Recommendation Report for Planning Permission

REF NO: BR/239/11/

LOCATION: The Beach
The Esplanade
Bognor Regis

PROPOSAL: Conversion of existing nightclub premises into two town houses & eight apartment flats

ELEVATION TO WATERLOO SQUARE AS EXISTING			
NORTH			
Scale	1:100 @ A3	Drawn By	ACB
Date	10/07/11	Checked	KEH
Drawing Number		4490 / 07

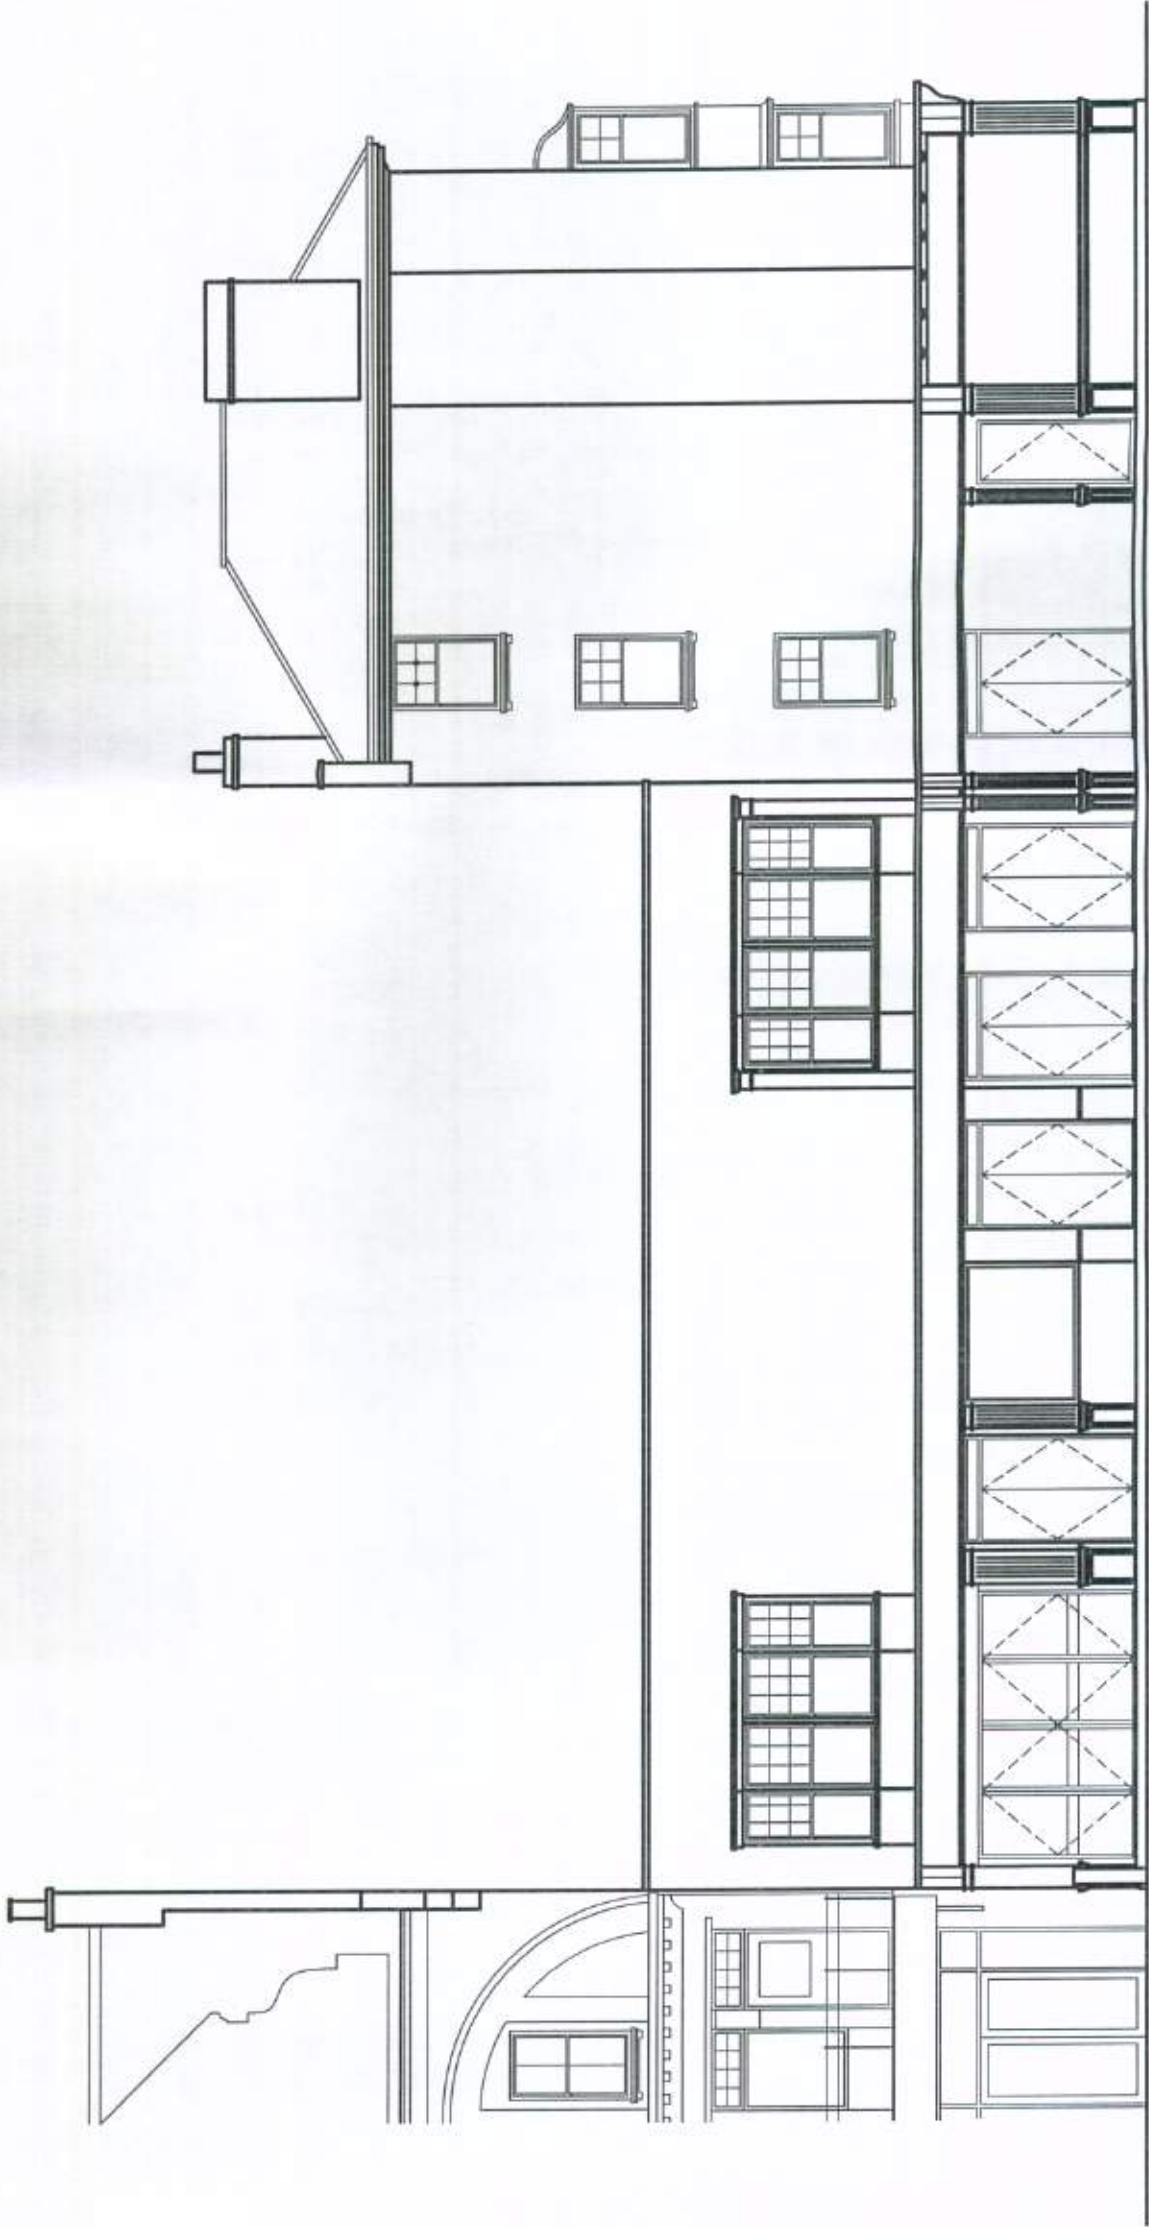
The concept of the change of use and redevelopment is acceptable in principle. Concern was raised over the appearance in Waterloo Square and the conservation area by the bland fenestration. However, the new plans for the Waterloo Square elevation are considered to be much more suitable for the proposal and the previous concerns are withdrawn.

Comments noted. Substitute plans have been submitted which overcome the visual concerns raised by the Conservation Officer. The concerns of the Environmental Health Officer have been overcome in the substitute plans which reduced the number of flat from 10 to 8 and the concerns regarding noise potential will be conditioned.

FIRST FLOOR PLAN
AS PROPOSED

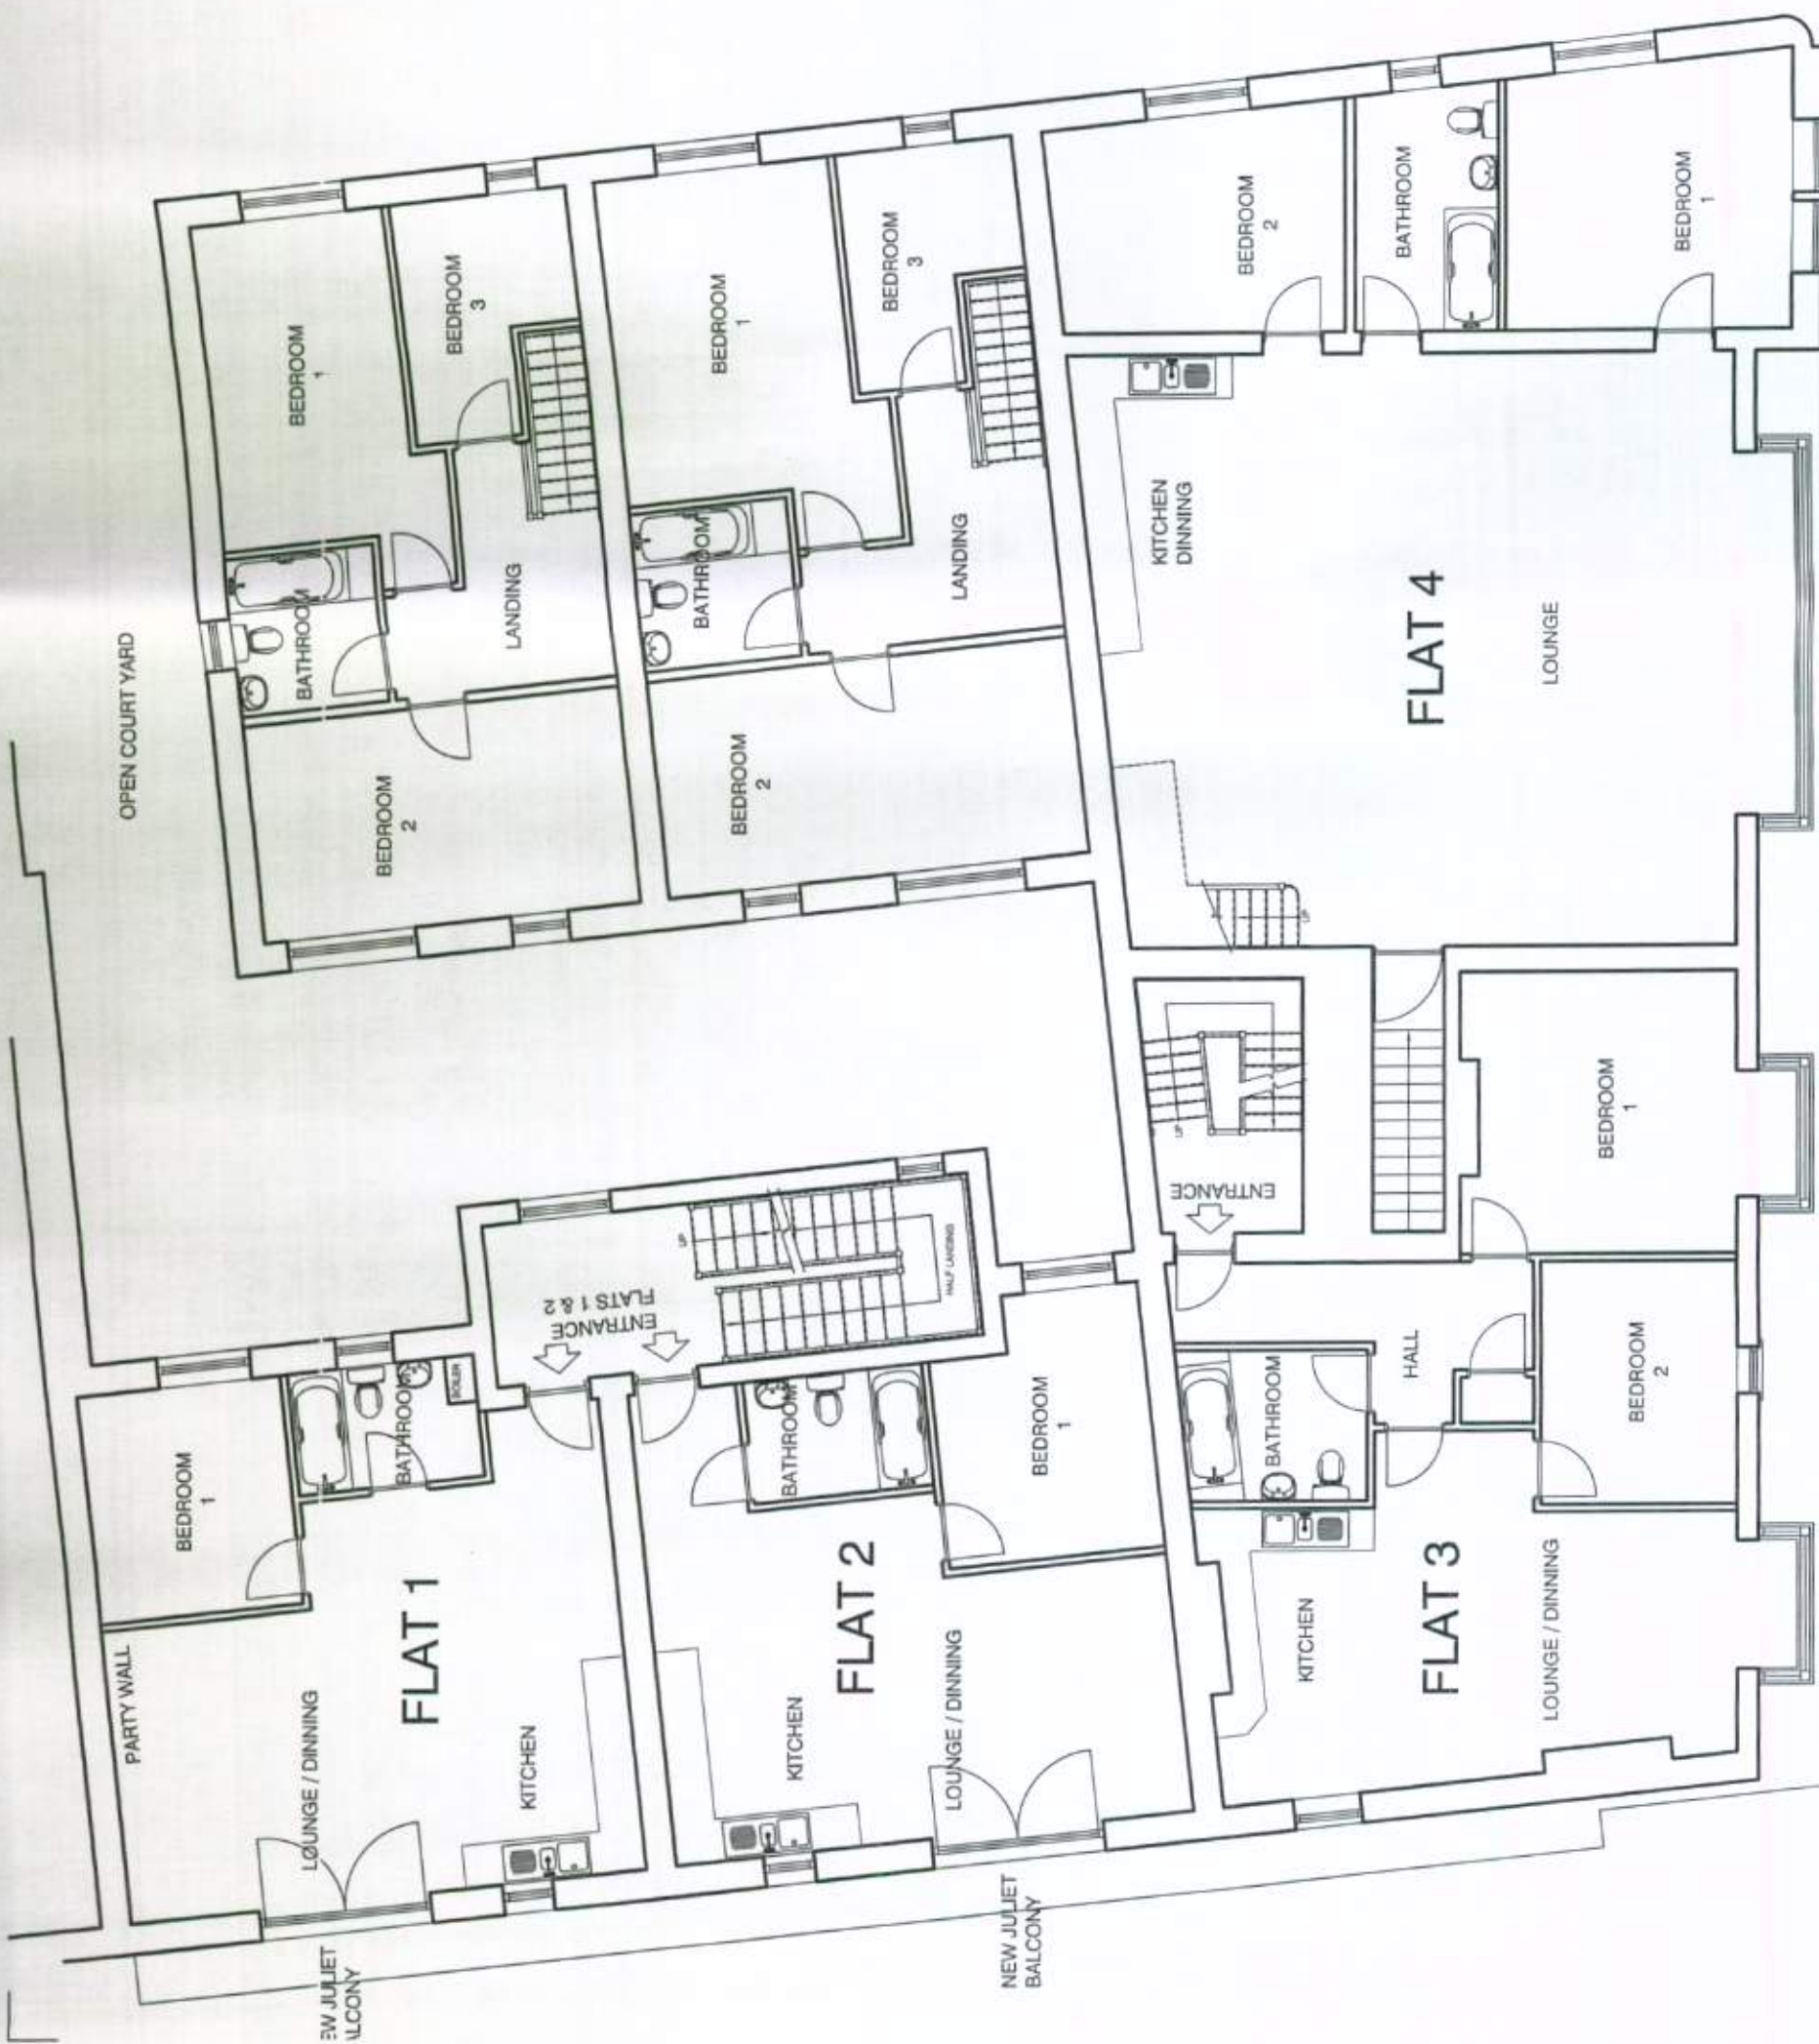
The means of escape is not acceptable when using other rooms of significant risk. This could be mitigated by escape windows at first floor but not above. Where flats have two bedrooms, bedroom one must be a minimum of 10 sqm. and bedroom two at least 7 sqm. with combined living/kitchen space of 23 sqm. Where there is one bedroom combined living space should be 14.5 sqm.
